From: Aarti O'Leary [REDACTED]
Sent: 28 May 2019 14:30
To: Stuart Corbey
Cc: Serena Page
Subject: RE: Worthing Road, Littlehampton - Planning application Ref: LU/59/19/PL

Subject: RE: Worthing Road, Littlehampton - Planning application Ref: LU/59/19/PL

I have looked through the updated surface water drainage strategy and have the following comments:

## **Appendix E – Proposed Drainage Strategy**

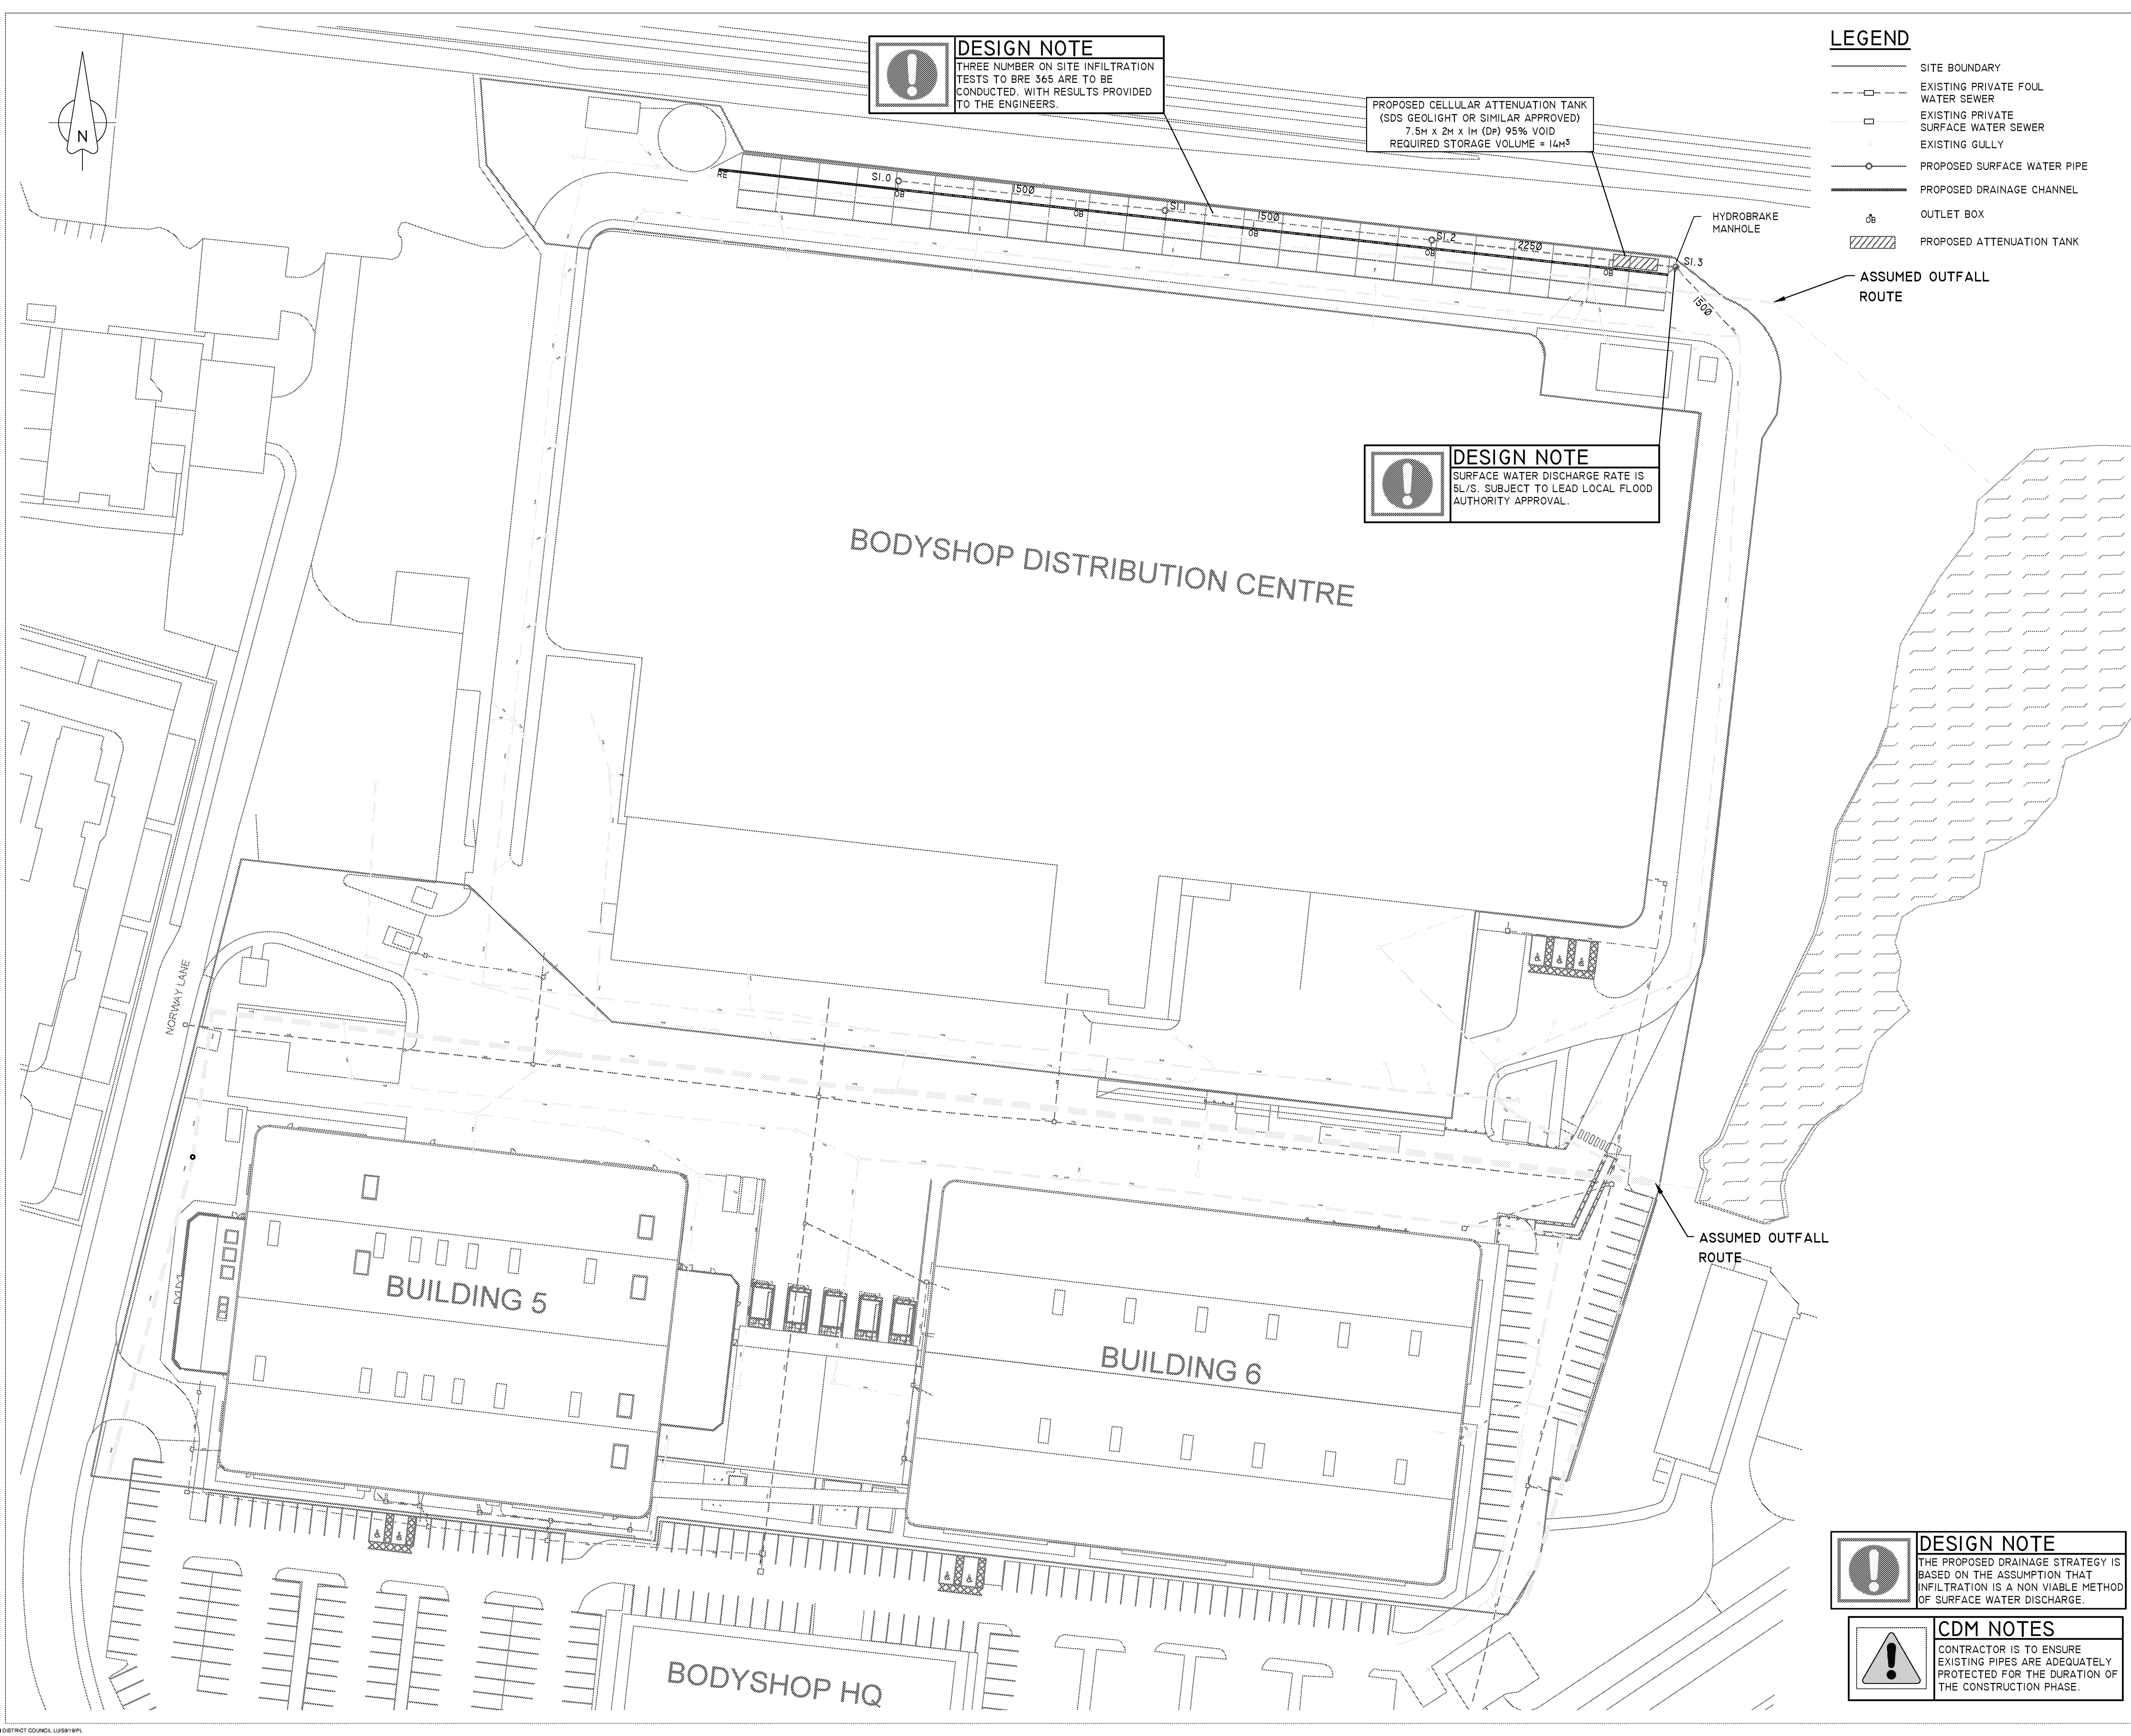
1. Worst case infiltration test results should be used in design, not an average.
2. What is the lifetime of the development, if it is over 40 years a 40% allowance for climate change should be utilised.
3. Safety factor of 4 is required, not 3.
4. Catchpits should be provided upstream of all connections to soakaways.

5. Please provide invert and cover levels on plan of inspection chambers/manholes.
